**RE: East Fork Jimmy Camp Creek at Creekside at Lorson Ranch, El Paso County,
Colorado CDR 192 (Kiowa Project No. 18020)**

I have prepared responses to Engineering's third set of review comments summarized in the County's memorandum dated May 5, 2020. Kiowa's responses are as follows:

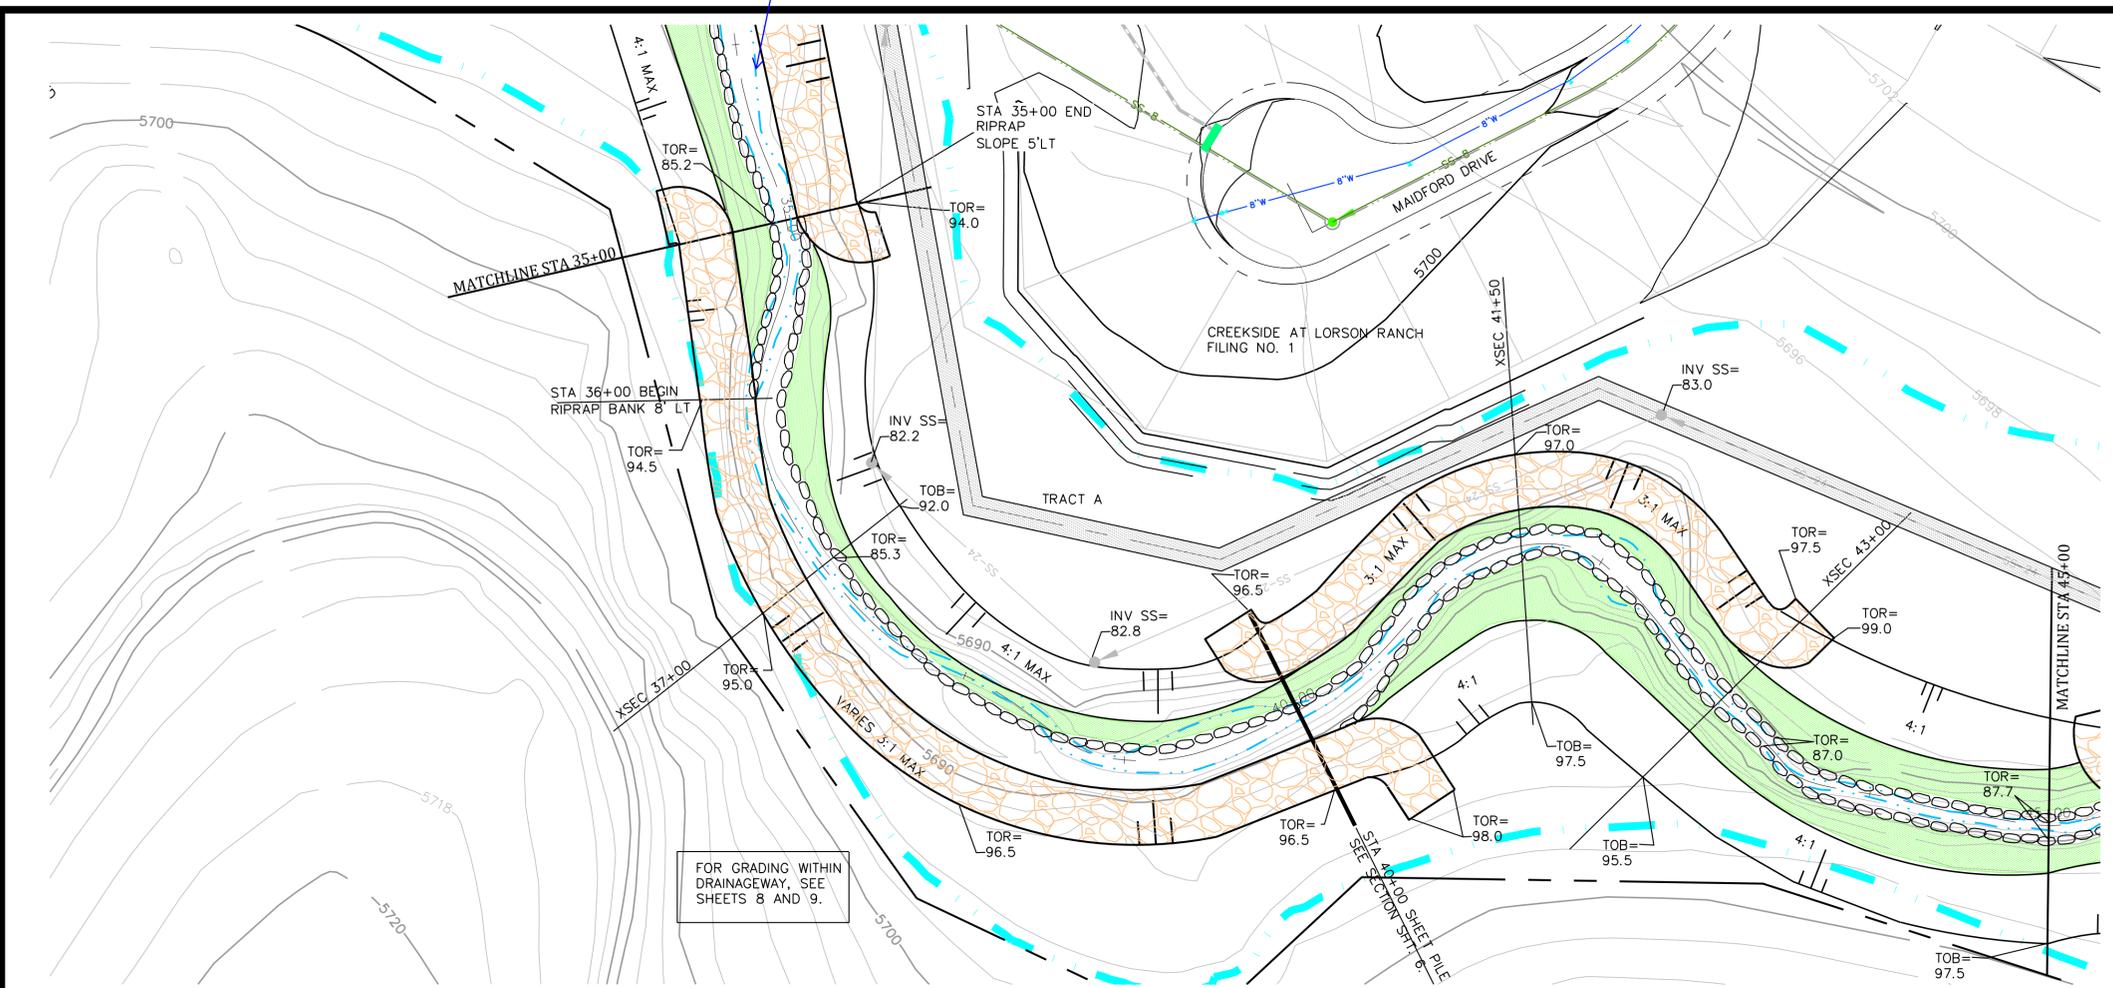
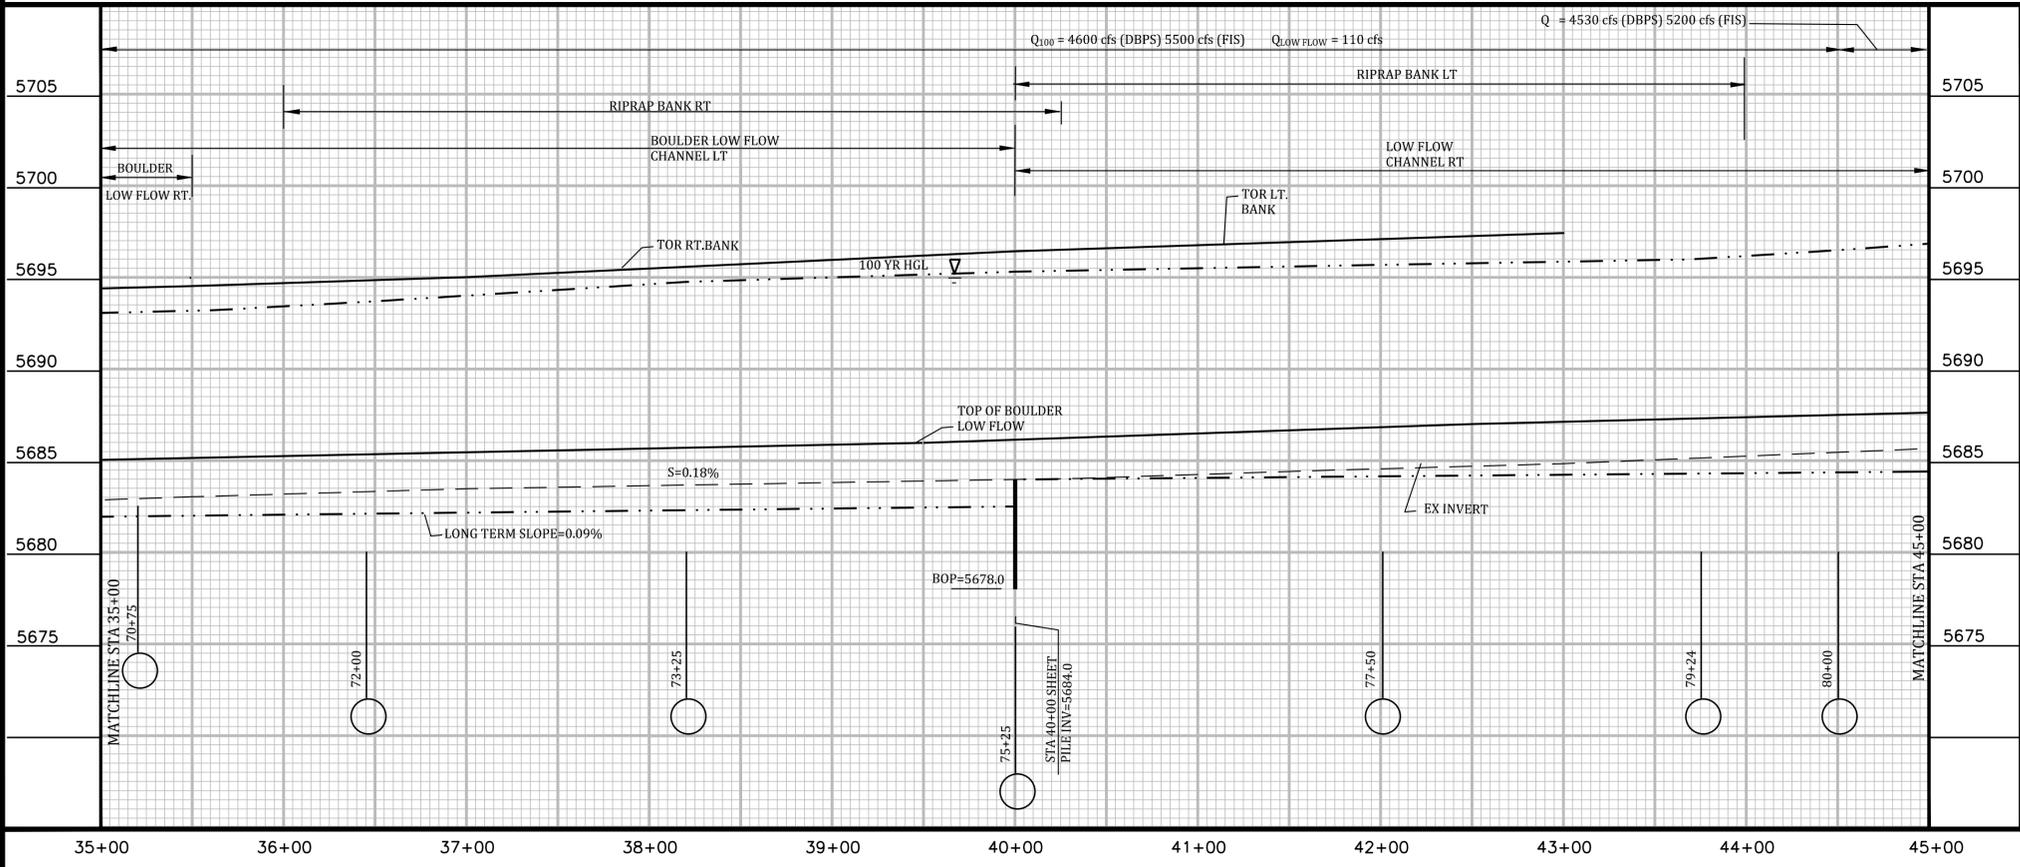
6. Kiowa has revised sheet 2 to reflect the storm sewer outfall for Creekside filing one FSD CR2. Invert shown on channel plans correspondence to plans by CORE Engineering. Kiowa has revised the grading from the spillway to the channel invert and has specified Type L soil riprap.
